Title: 2nd Response to OCC Highways Comments

Date: May 2022

- 1.1 Jubb has been commissioned by Hallam Land Management Ltd (HLM) to provide highways and transportation advice in relation to proposals for a residential-led mixed use development on Land north-east of the railway line in North West Bicester.
- 1.2 This technical note sets out, in table format, a response to Oxfordshire County Council's transport and highways comments relating to Jubb's Technical Note 02.

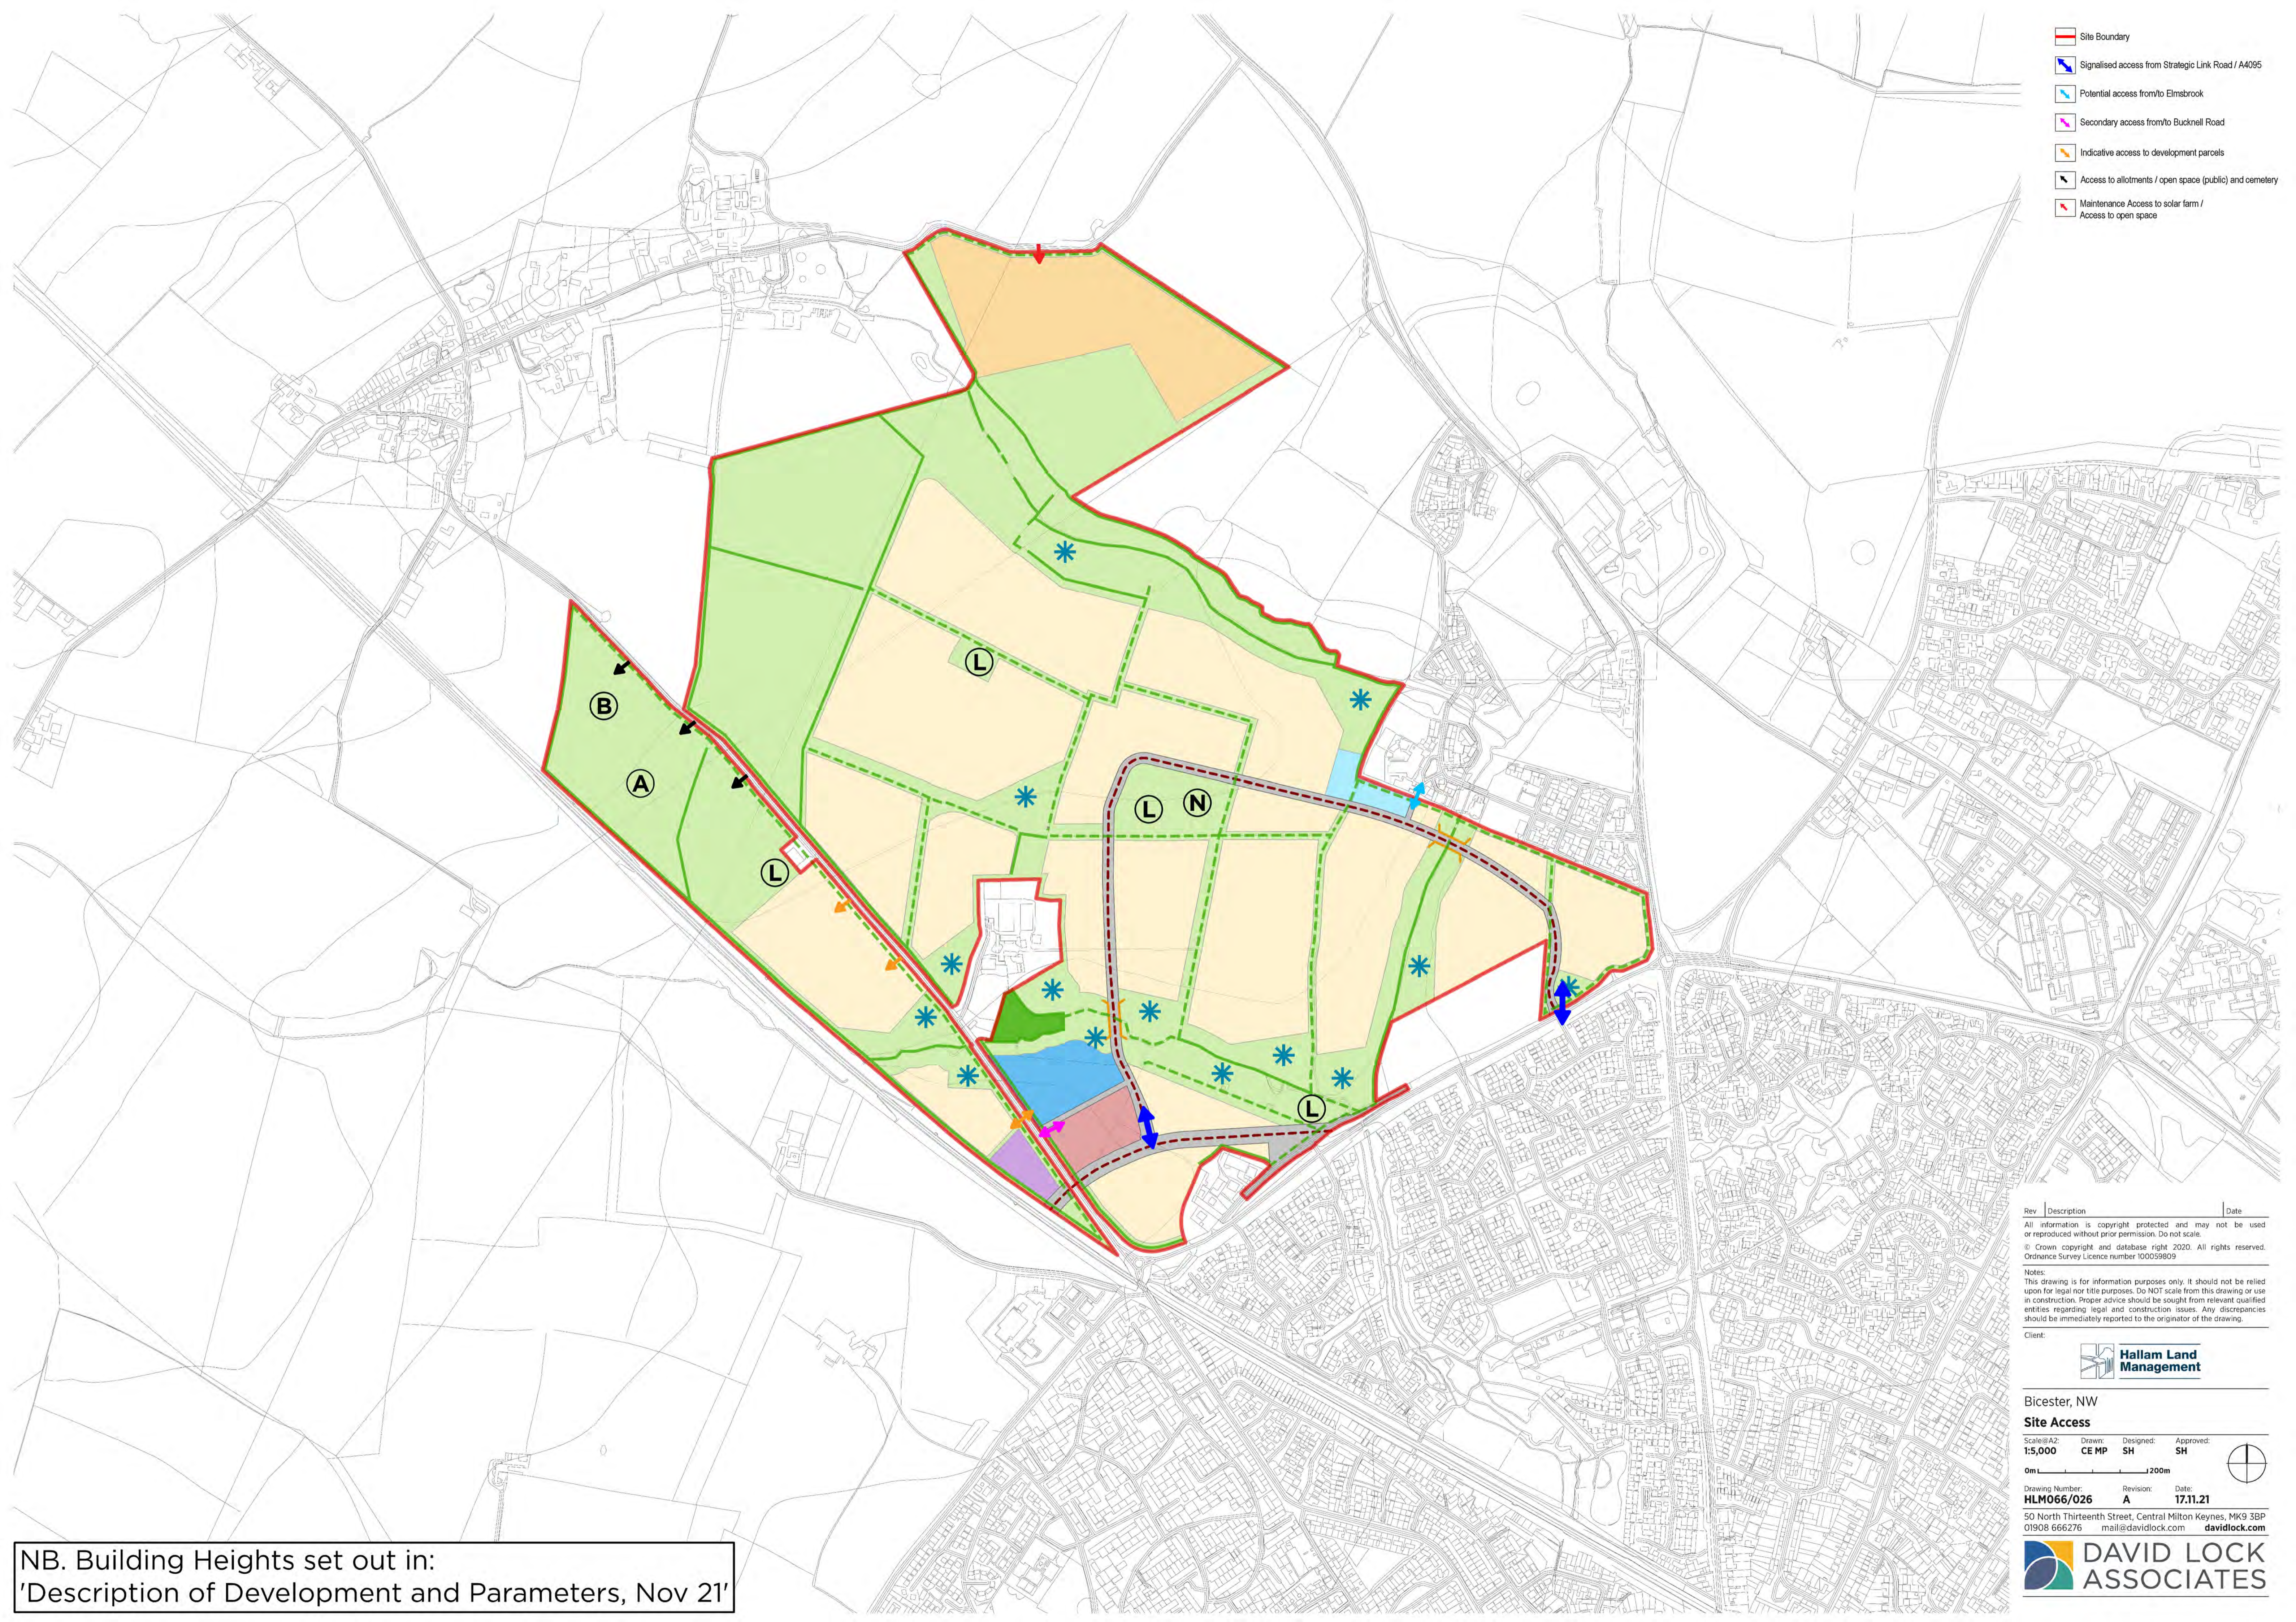
7.2.6/Fig 7.4	The proposed vehicular access strategy does not accord with the NW Bicester Vehicular Access Strategy in the NW Bicester Masterplan Access and Travel Strategy, which shows the spine road leading into Charlotte Ave within Elmsbrook, rather than joining Lords Lane S of Banbury Road as proposed. This is also not in accordance with the public transport strategy and would jeopardise the ability to serve NW Bicester north of the railway, including Elmsbrook, with a single bus service. In any case, the junction would need to be modelled for traffic capacity, as well as the adjacent, Banbury Rd junction, which would have different traffic flows.	Discussions with A2D are ongoing in respect of the delivery of the access to Charlotte Avenue. The access could take the form of enabling all vehicle movements and active travel or it could form a bus only link alongside active travel. Modelling of the A4095/Banbury Road junction is noted.	The bus connection is vital and must be secured to make the development acceptable.	Discussions with A2D are still ongoing.

Fig 7.4	The secondary access onto Bucknell Road is too far south and therefore not in accordance with the Masterplan Strategy, which aimed	With a combination of highway design and traffic calming and traffic management measures along Bucknell Rd journey times to Bucknell	Please provide details of meetings and progress with discussions.	Public meeting held on 14.03.2022 where traffic calming proposals for Bucknell Road and Bucknell village were presented (see Appendix B). A

Document / Paragraph	OCC Comments to TA	Jubb Comments	OCC Comments to TN02	Jubb Comments
	<p>be a limit on development coming forward before the onward connection south of the railway is opened.</p> <p>Also two accesses are mentioned off the SLR (realigned section of the A4095). Only one is shown on the plan in Figure 7.4 – this needs clarification.</p> <p>A number of accesses are indicated off Bucknell Road, and one off Bainton Road, for which no details are provided. As approval is sought for accesses as part of this outline application, details of each access from the highway must be provided as part of the application.</p> <p>The bus only link between the A4095 realignment and Lords Lane/Bucknell Road is not shown - that was part of the NWB masterplan movement and access</p>	<p>on plan HLM066/026A to clearly shows accesses as illustrative and the proposal for the use of a condition to ensure details of the accesses are submitted and approve:</p> <p><i>“Notwithstanding the submission of drawing no. HLM066/026A in relation to the consideration for approval of the means of access to the Proposed Development, the Site Access positions for the ‘Potential access from/to Elmsbrook’, ‘Indicative access to development parcels’, ‘access to allotments/open space (public) and cemetery’ and ‘Maintenance access to solar farm/Access to open space’ are shown for illustration purposes only. Full details of the exact positioning and treatment of these site accesses shall be submitted to the Local Planning Authority for approval as part of the reserved matters application for that Part of the Development. The development shall be implemented in full accordance with the approved details.”</i></p> <p>This bus only link was removed from the OCC design for the A4095 realignment, and the design reflects</p>	<p>Depends on CDC's view on whether it is acceptable to reserve details of some accesses (including position).</p>	<p>Discussion is ongoing with CDC. The planning officer has not rejected the use of a condition but has also suggested an alternative may be to alter the description of the development.</p>

Document / Paragraph	OCC Comments to TA	Jubb Comments	OCC Comments to TN02	Jubb Comments
	<p>framework. However, provided an acceptable bus loop can be provided, to link with the bus route within the Exemplar site, this would be acceptable, as the buses could access the site from the Banbury Road rather than Bucknell Road. However, the link through to the Exemplar site is only shown as a 'potential' access.</p>	<p>that. Noted. See response to 7.2.6/Fig 7.4.</p>
